REFERENCE: WEST MESA PARK (FORMERLY) PARADISE RV PARK

PROJECT NUMBER: 1008330/EPC - 40073 PHASE II

PR-2024-010907

Please find attached updated Site Development Plans for the West Mesa Park AKA Paradise RV Park.

SP-2

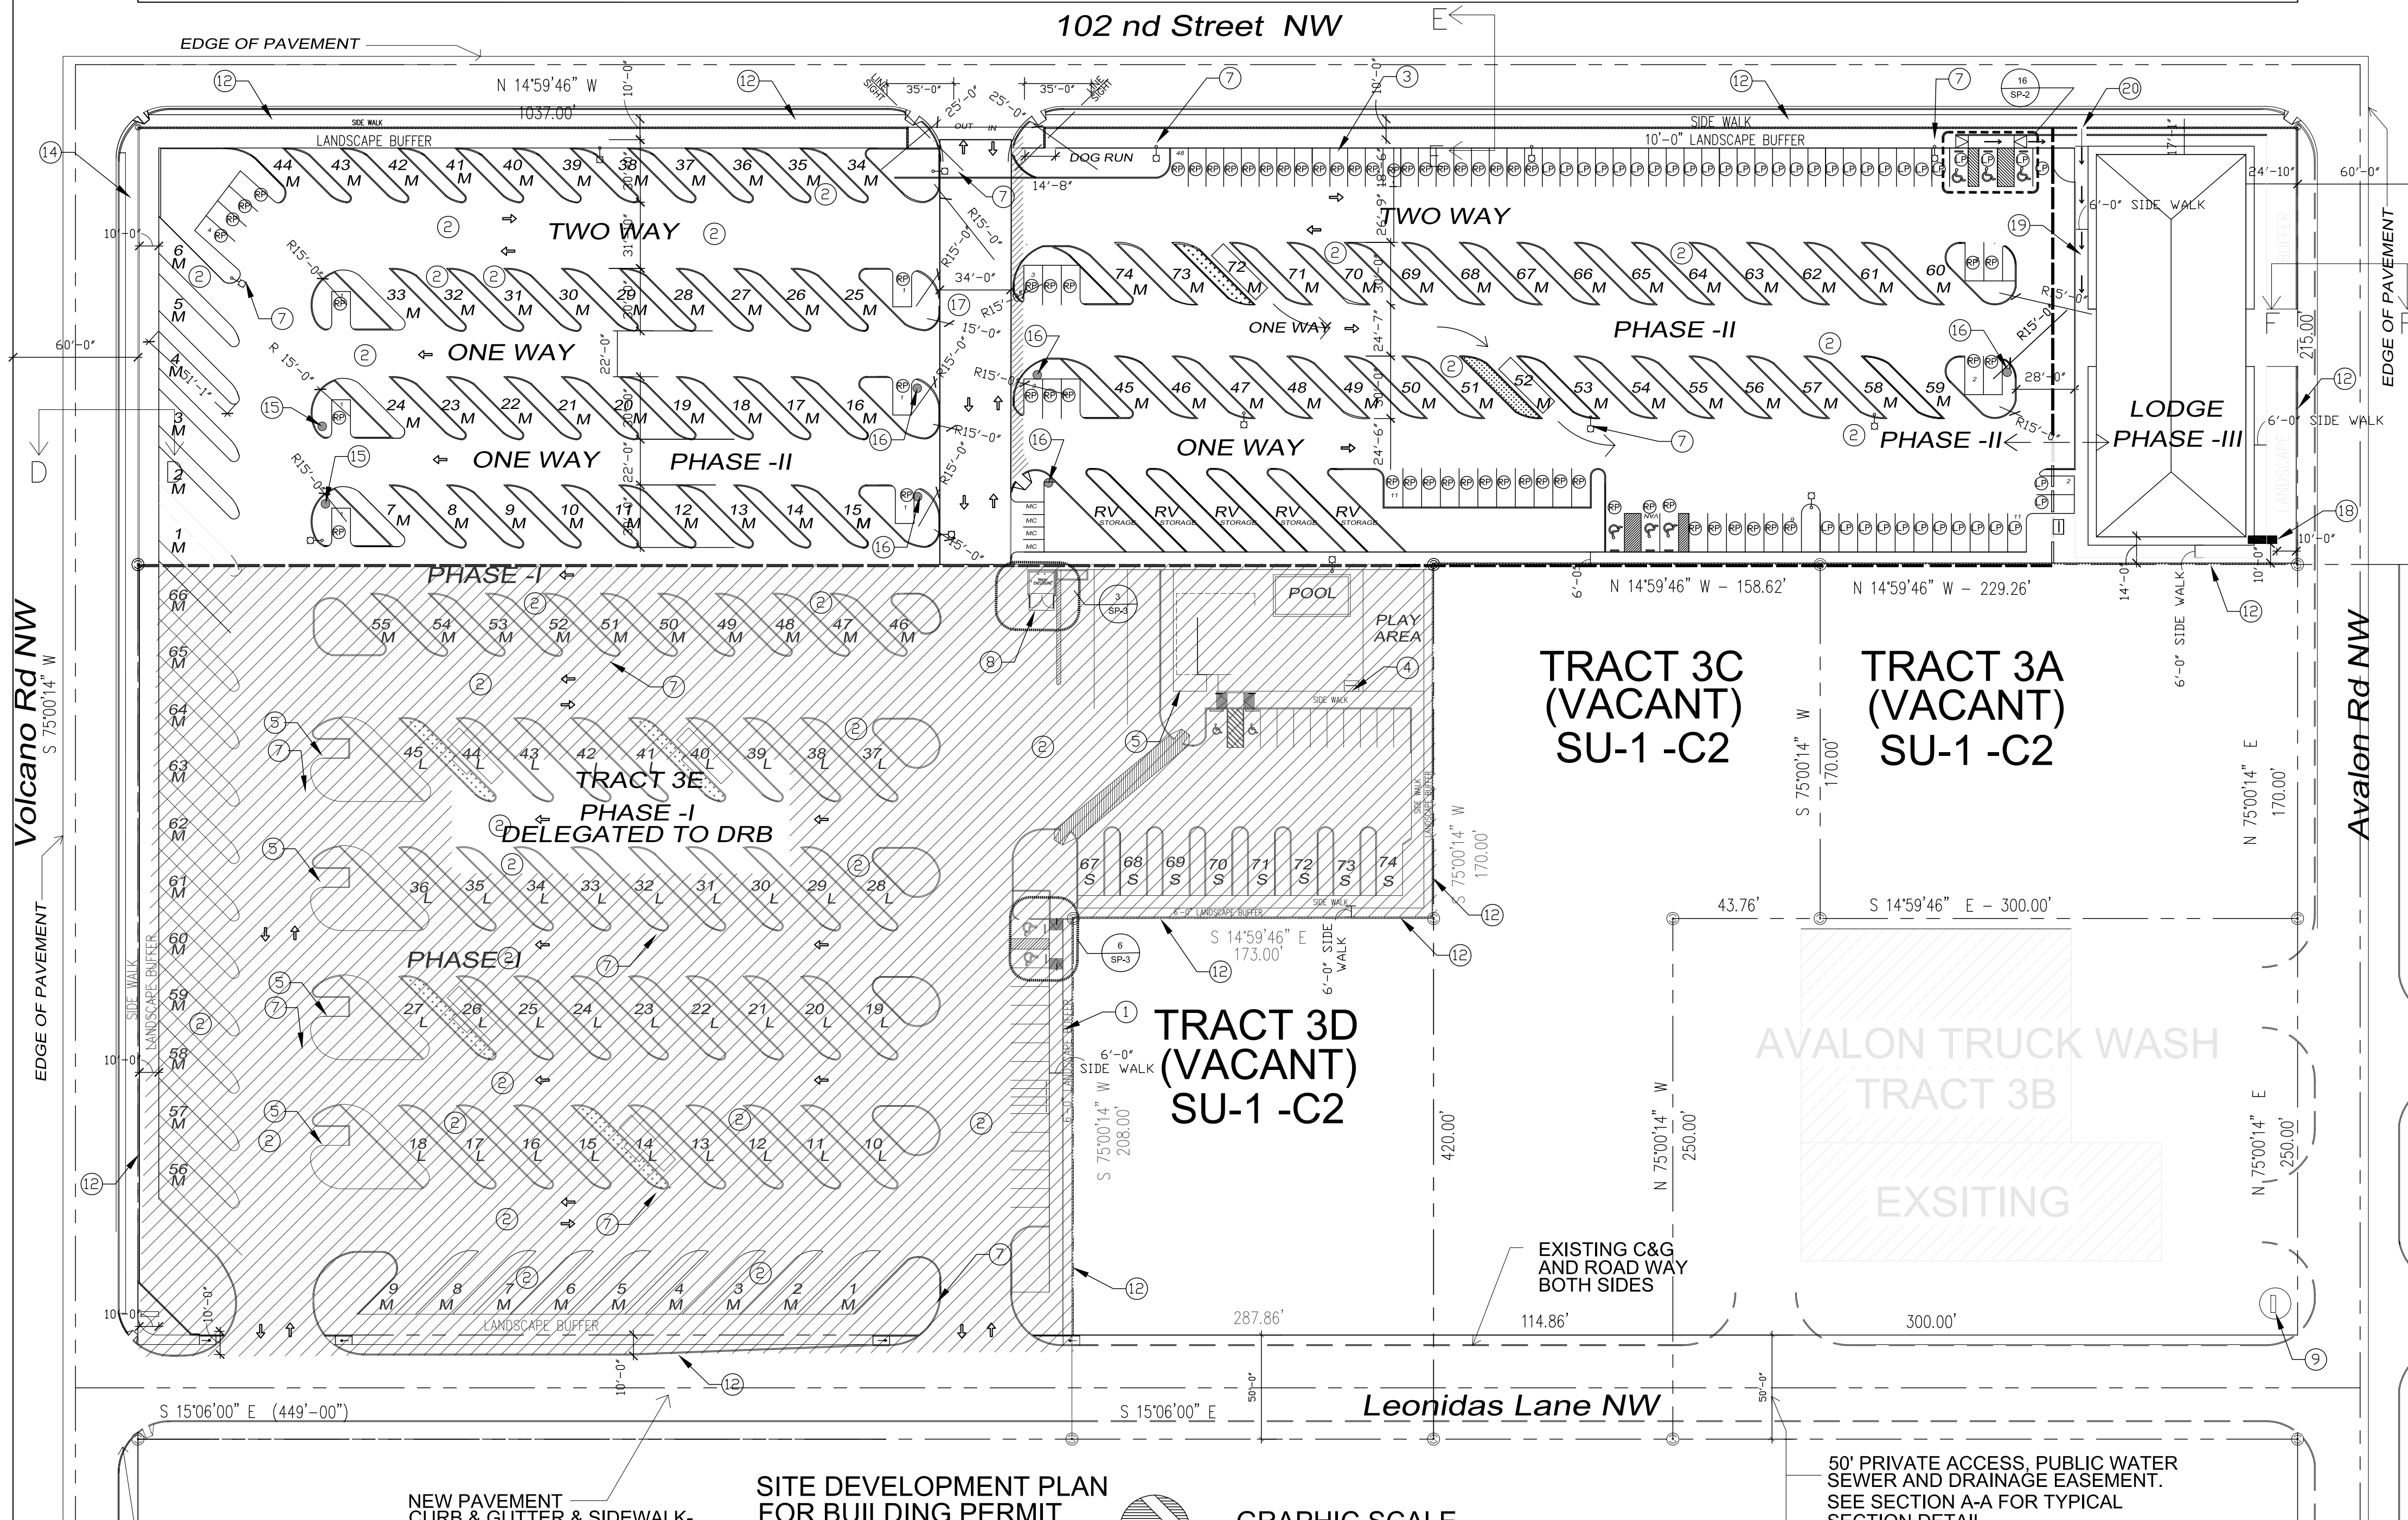
Based on the comments from Code Enforcement dated 10-30-2024 and 02-12-2025, the Site Plan has been revised and the Parking Spaces is now increased to One Hundred and One (101) spaces. The Log Cabins / Casitas has been eliminated to provide for additional parking. I believe this will be adequate for the camp site as well as the proposed apartment building which will be constructed in the Phase III of this project.
